CITY OF PORTLAND

August 22, 2003

RE: 49 Sheridan Street/ 87 Monument St – 017-B-012 – R-6 – application #03-0897

I am in receipt of your permit application to add a 13.5' x 13.5' roof top addition with new roof decking and to extend the chimney. Your permit is on hold because you have not submitted enough plans to determine that you have met the requirements of the Zoning Ordinance.

ROOF PLAN

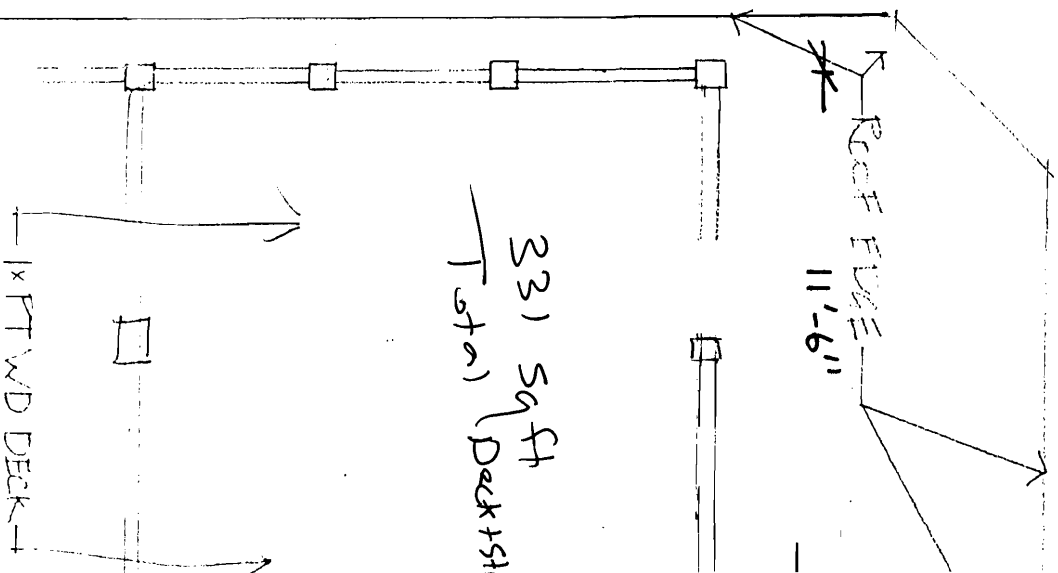
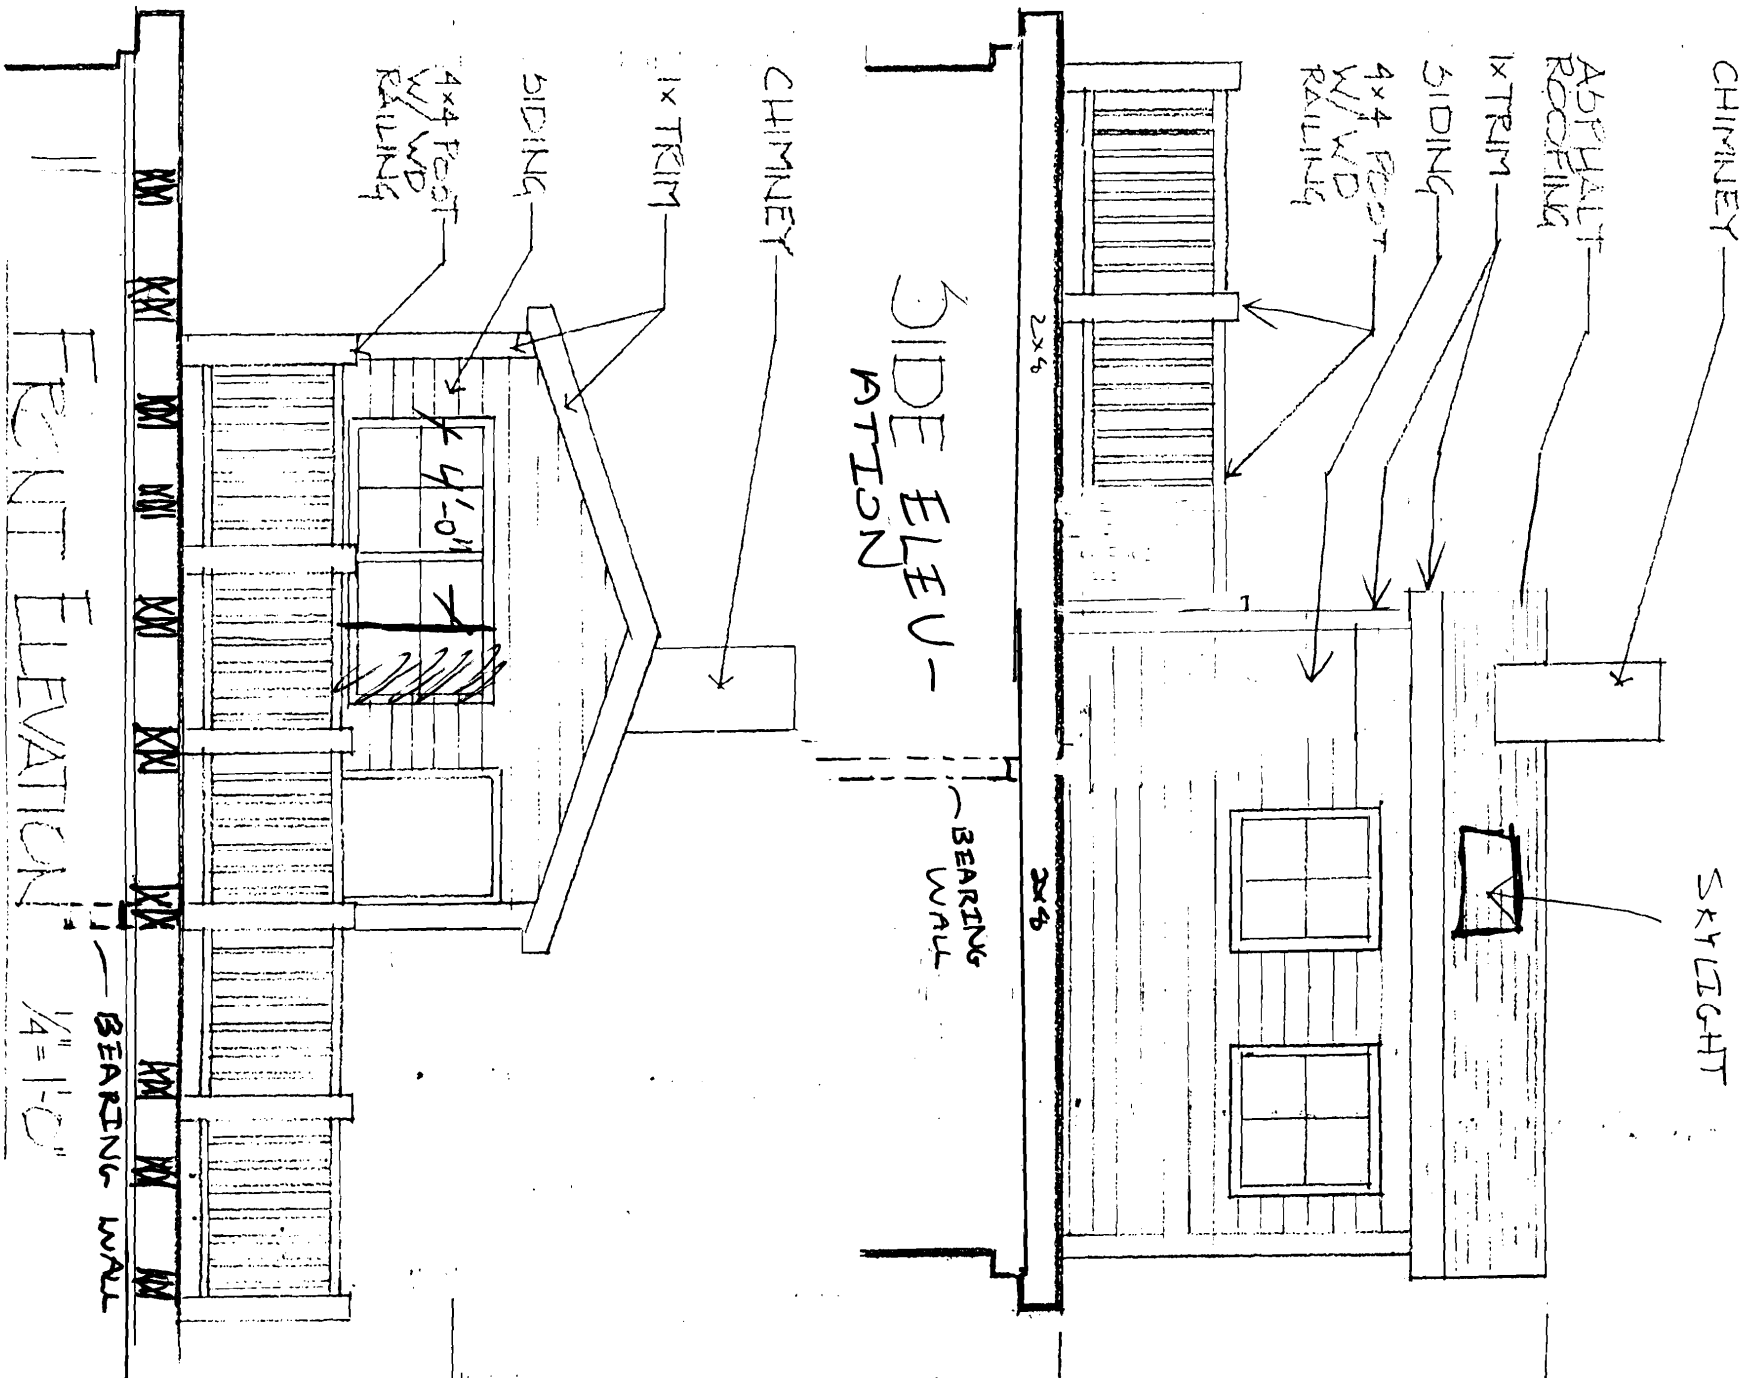
Section 14-139 limits building structures in the R-6 zone to no more than forty-five feet in height from grade. You have not submitted enough detail for me to determine that your new structure and decking would meet the maximum height limitation. We will also need a plan showing specifically where on the existing roof this new decking and structure will be located. Your permit will be on hold until this information is received. This project is also subject to site plan/ or site plan exemption review through the Planning Division. You must apply with Planning for such an approval.
